**Plot 95 Wave 2  
Graven Hill  
Circular Road  
Ambrosden**

**17/02365/REM**

**Proposal:** Reserved Matters to application 16/01802/OUT – Detailed plot design for plot 95 (Increase of GIA of Plot 95 from 80 sqm to 92 sqm)

Proposed Elevations

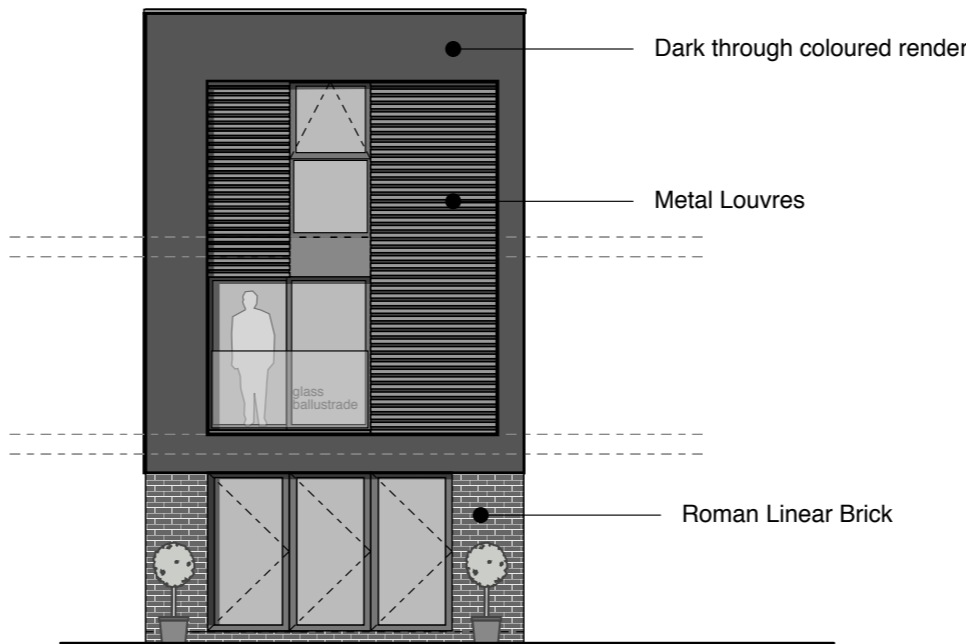
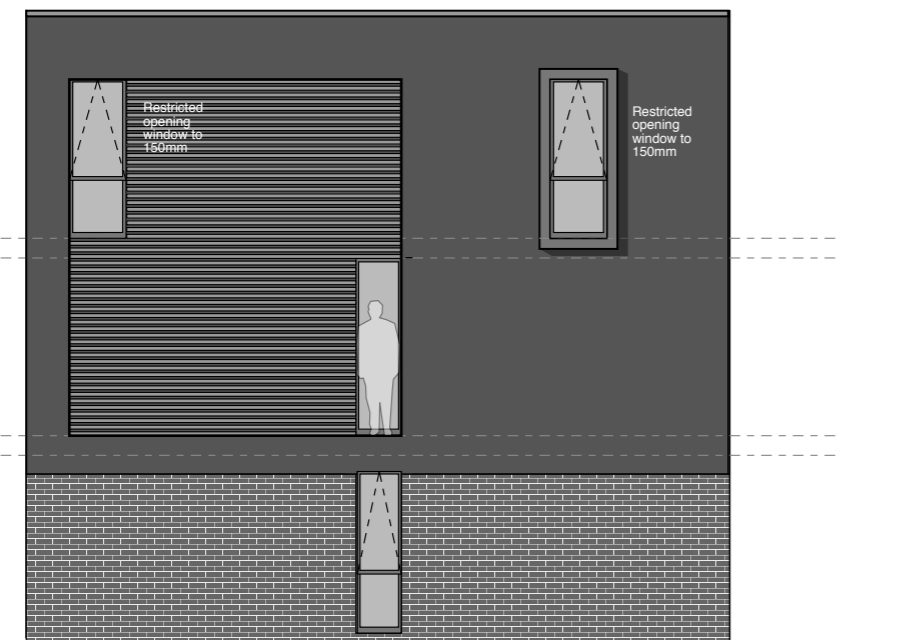
- 2.1. The current application seeks reserved matters approval for a detached 3 bedroomed three storey dwelling on the site. A bedroom is proposed on the first floor and the other two bedrooms are proposed on the second floor. This dwelling would be constructed from brick to the ground floor and render above. Metal louvre panels are also proposed on the 1<sup>st</sup> and 2<sup>nd</sup> floors.

8.7 The building height does not exceed 8.1m.

East Elevation

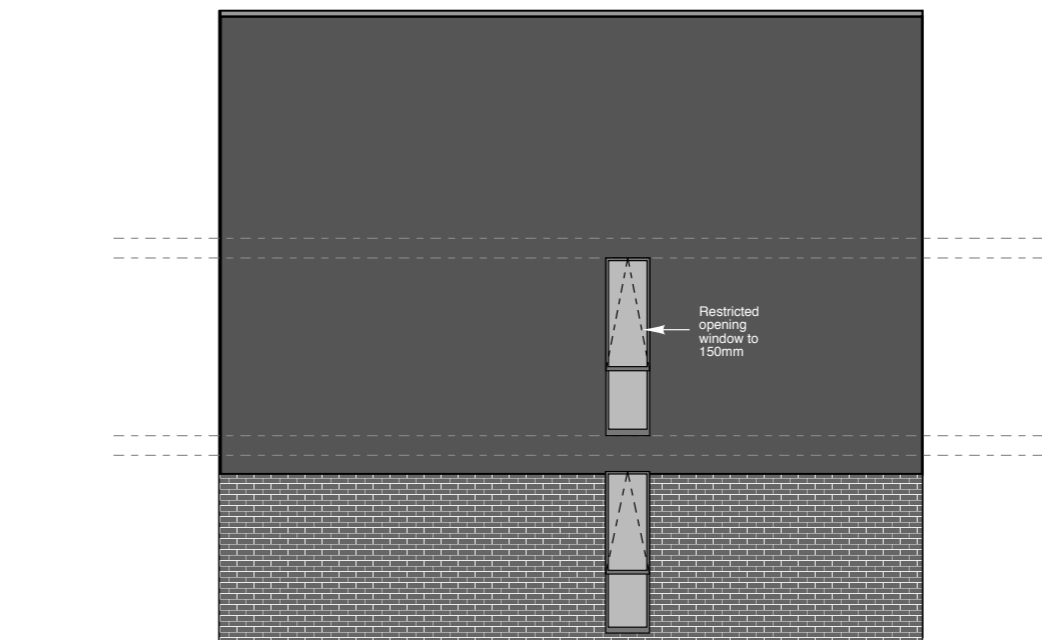
8.14 Windows in the side elevations of the upper floors are to open but the opening is to be restricted to 150mm. The plot to the east of the site (Plot 94) has received confirmation of compliance and as such normally such windows should be obscurely

glazed and non-opening unless the opening part is more than 1.7m above floor level. In this instance it is considered to be acceptable in terms of overlooking for the first floor window in the eastern elevation to be opening as submitted but it needs to be obscurely glazed due to a first floor window in the side elevation of Plot 94.

3. Prior to the first occupation of the dwelling hereby approved, the first floor window in the east elevation of the dwelling shall fully glazed with obscured glass that complies with the current British Standard, and retained as such thereafter.

Proposed Plans & Section

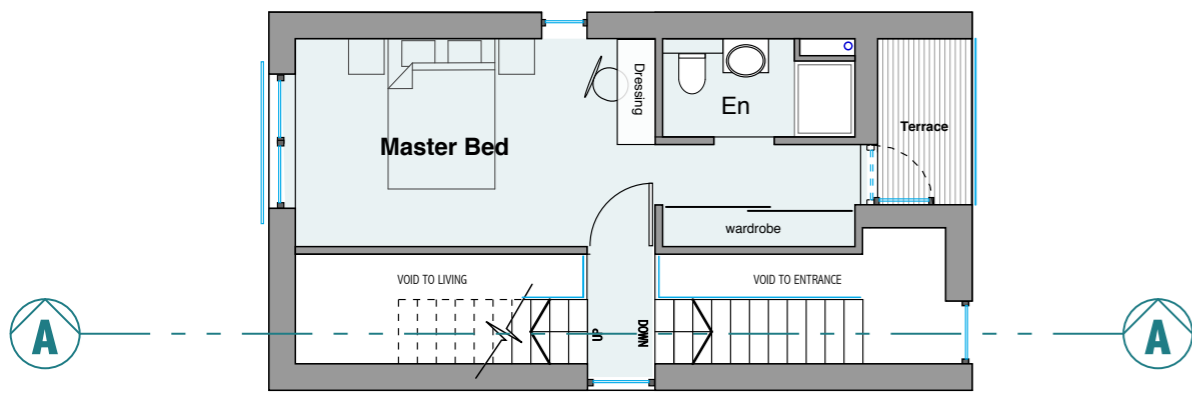
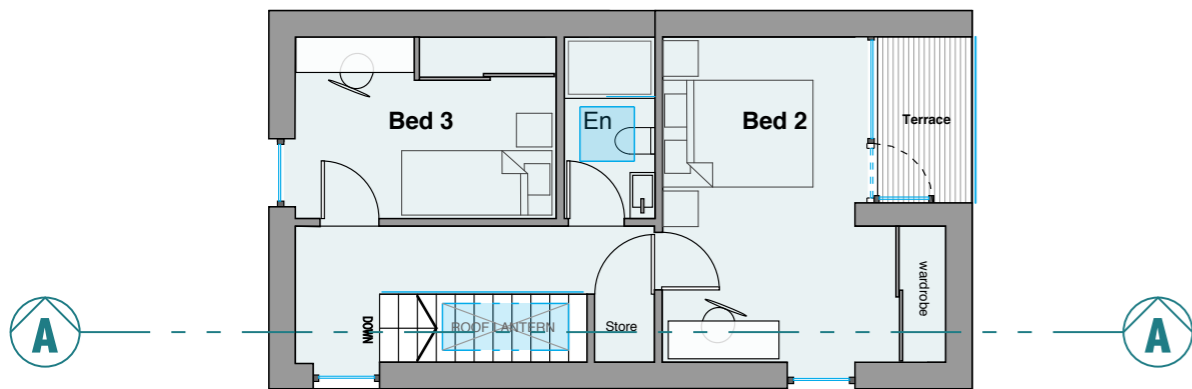
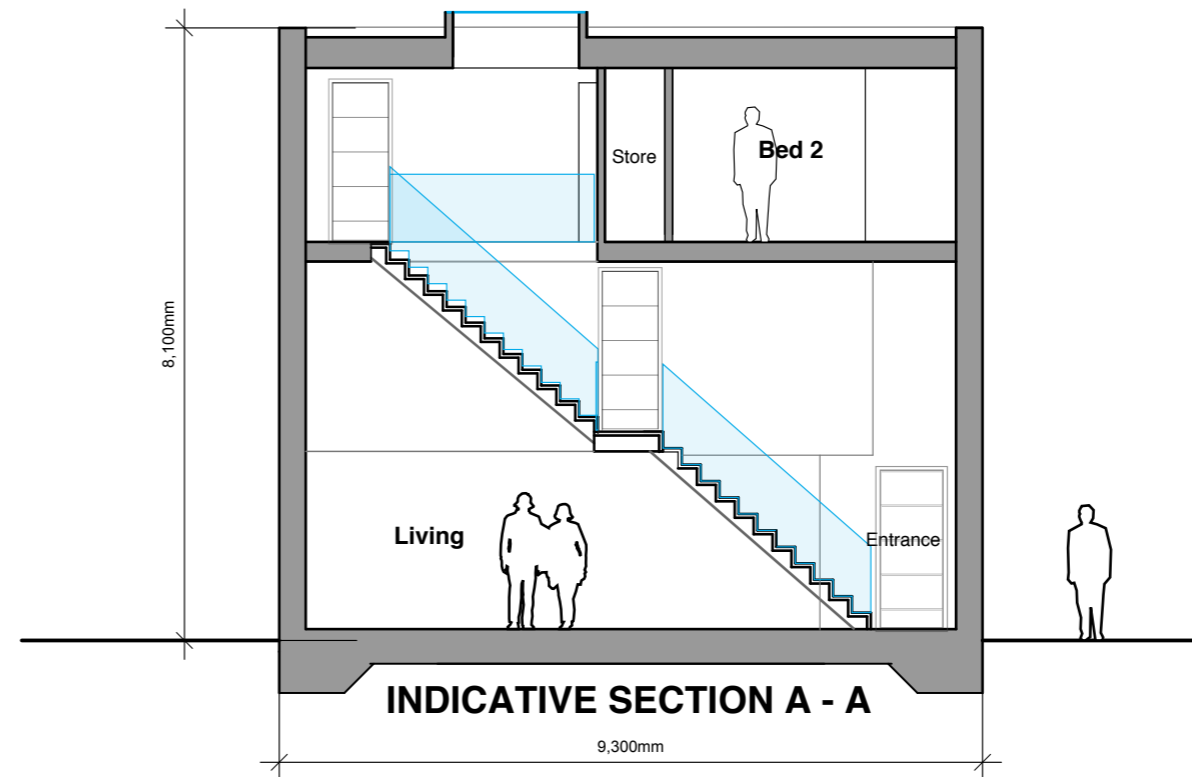
8.8 The Gross Internal Area stated for this plot on the approved parameter plan (drawing number A-L-742 Rev K) is shown as a maximum of 80m<sup>2</sup>. The proposed design comprises a dwelling which is laid out over three floors and has a total Gross Internal Area (GIA) of 92m<sup>2</sup>. The proposed GIA therefore exceeds the GIA set out on the approved parameter plan. The proposed dwelling however is located within the build zone and within the maximum build height for the plot and therefore the proposed dwelling would sit within the scale parameters approved and would sit comfortably within the development.
